WEST SUSSEX COUNTY COUNCIL CONSULTATION

TO:	Arun District Council FAO: Simon Davis
FROM:	WSCC - Highways Authority
DATE:	14 th July 2021
LOCATION:	Clays Farm North End Road Yapton BN18 0DT
SUBJECT:	Y/18/21/RES Approval of reserved matters following Y/62/18/OUT for 33 No. residential units, access, landscaping & associated works. This site is in CIL Zone 3 & is CIL Liable as new dwellings.
DATE OF SITE VISIT:	n/a (desk-top study)
RECOMMENDATION:	No objection
S106 CONTRIBUTION TOTAL:	n/a (see outline permission)

This is the second WSCC Highways (CHA) response to the above planning application seeking approval of reserved matters following Y/62/18/OUT for 33 No. residential units, access, landscaping & associated works.

MBSK210525-03

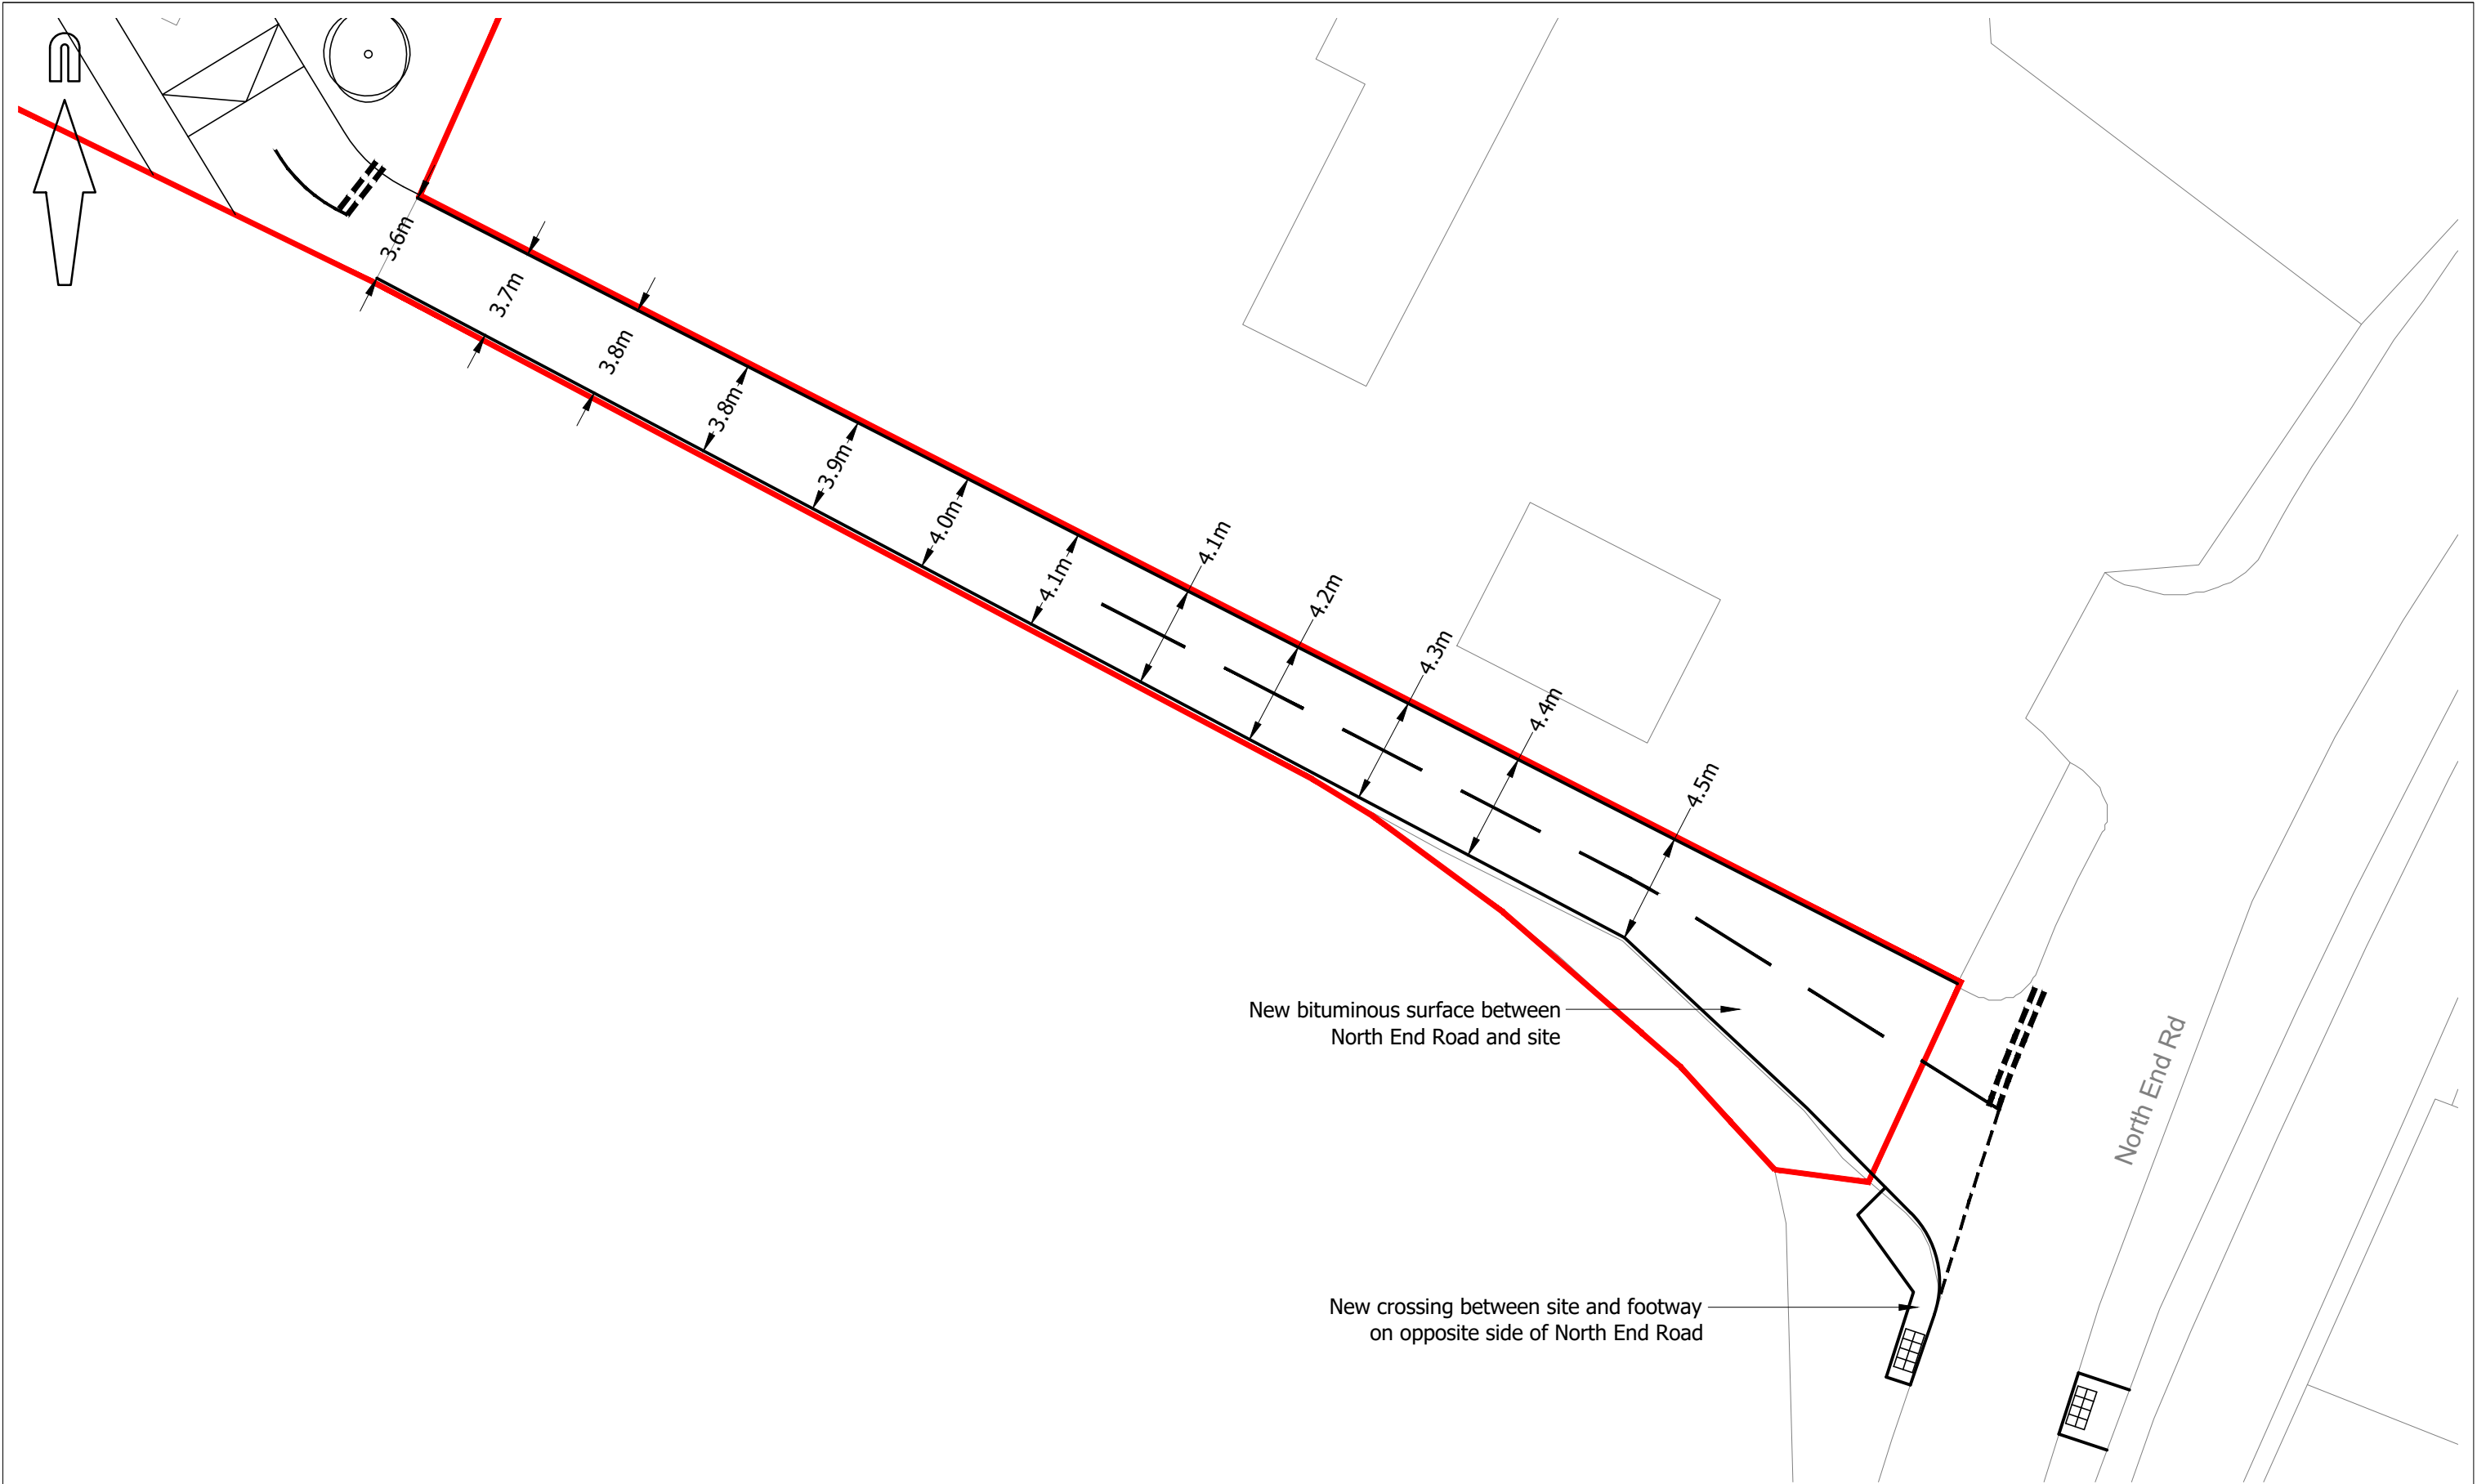
1. A detailed plan showing the section of access road from North End Road up to the start of the internal site layout. Please also provide the Road Safety Audit carried out for that section of road. This is required to show how it and the internal layout are proposed to work together. *A Safety Audit was carried out for the junction works with North End Road at the time of the outline planning application. Following this, a new plan has now been provided showing the access narrowed slightly at the point it joins North End Road to provide a short section of continuous footway running from North End Road into the first 15-20m of the site access to provide a separate footway for pedestrians before they have to walk in the shared-space area with vehicles. Additionally, swept-path diagrams for a refuse vehicle entering the access road coming-across a car leaving the development as shown on Drawing No. MBSK210702-01 Rev. P3 have been provided. While there is some overhang of part of the new footway caused by a refuse vehicle on entering from the north, this might only occur if the driver were faced with a vehicle leaving at the same time, otherwise they would have the full width of the access road to use upon entry. However, trips by refuse vehicles to the site would be very infrequent (likely once per-week) and drivers would themselves have an obligation to negotiate the junction carefully respecting other highway users including pedestrians which happens in many similar circumstances and scenarios elsewhere.*

MBSK210702-02

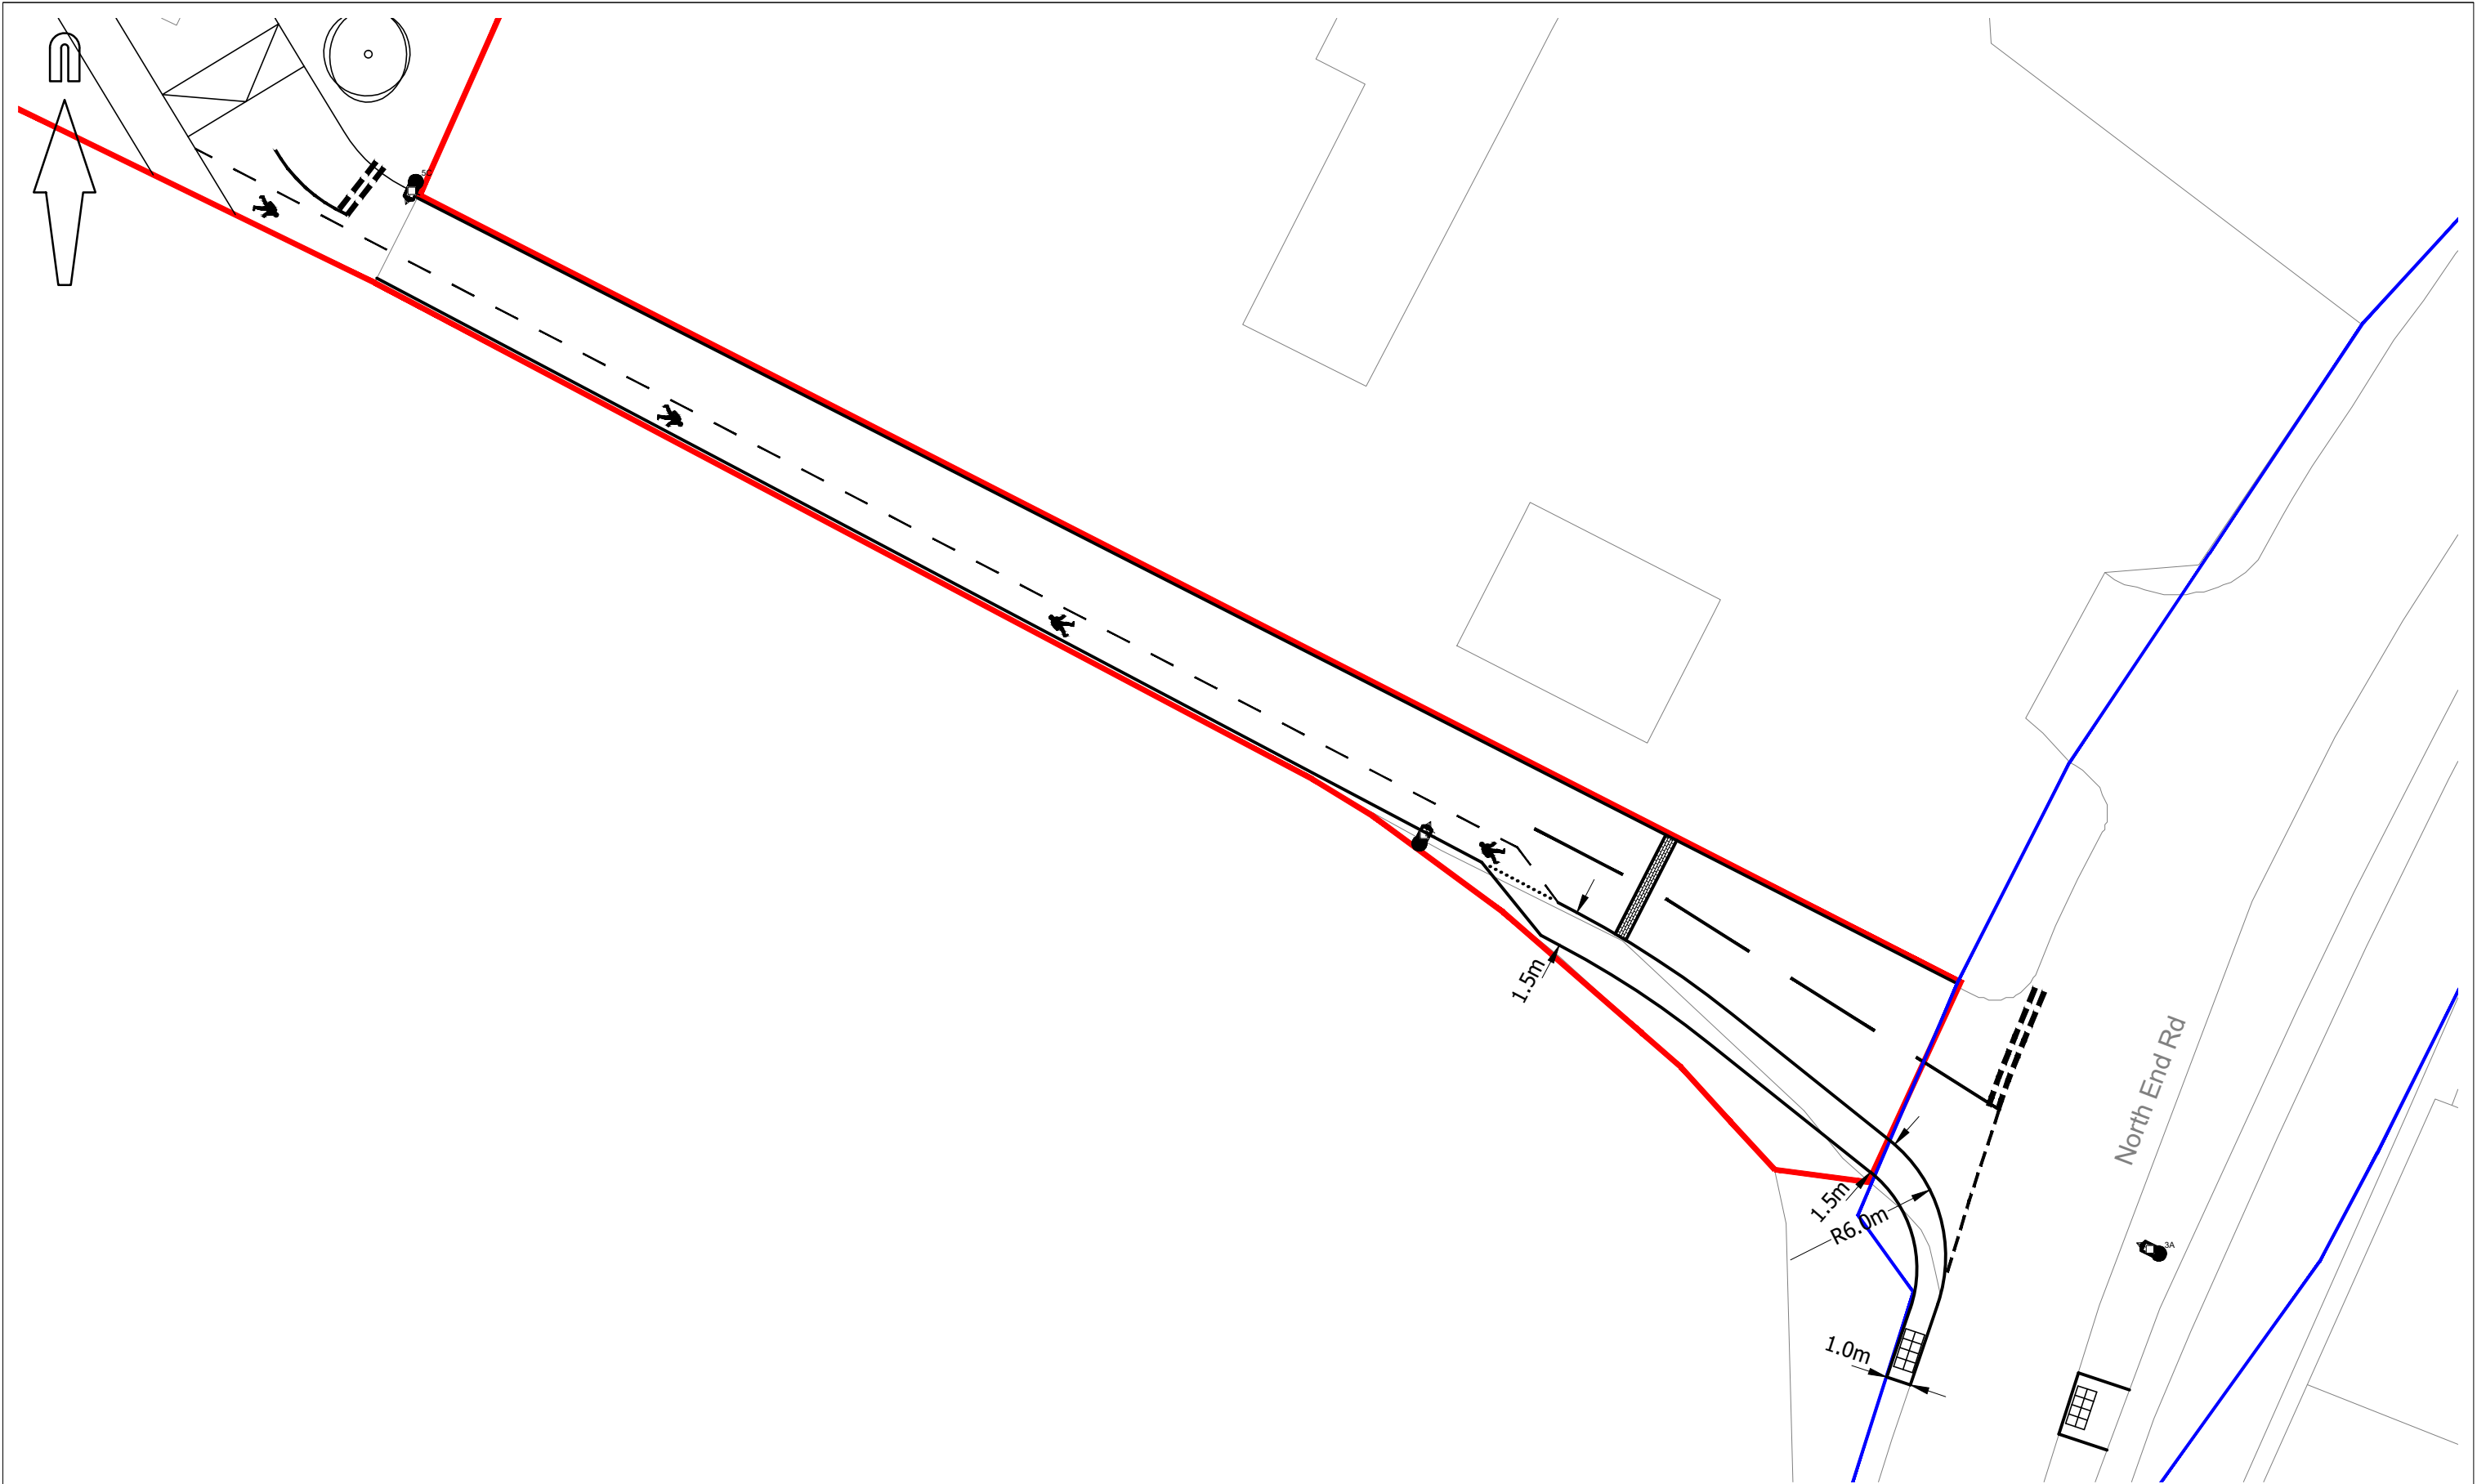
The new layout plan (Drawing No. MBSK210702-02Rev. P1) has also been shown to the applicant's Road Safety Auditor (email from Martyn Parr of Mayer Brown to Alex Philpot, also of Mayer Brown Ltd., dated 13th July 2021) who considers that no material increase in risk to road users will arise as a result of the latest proposals.
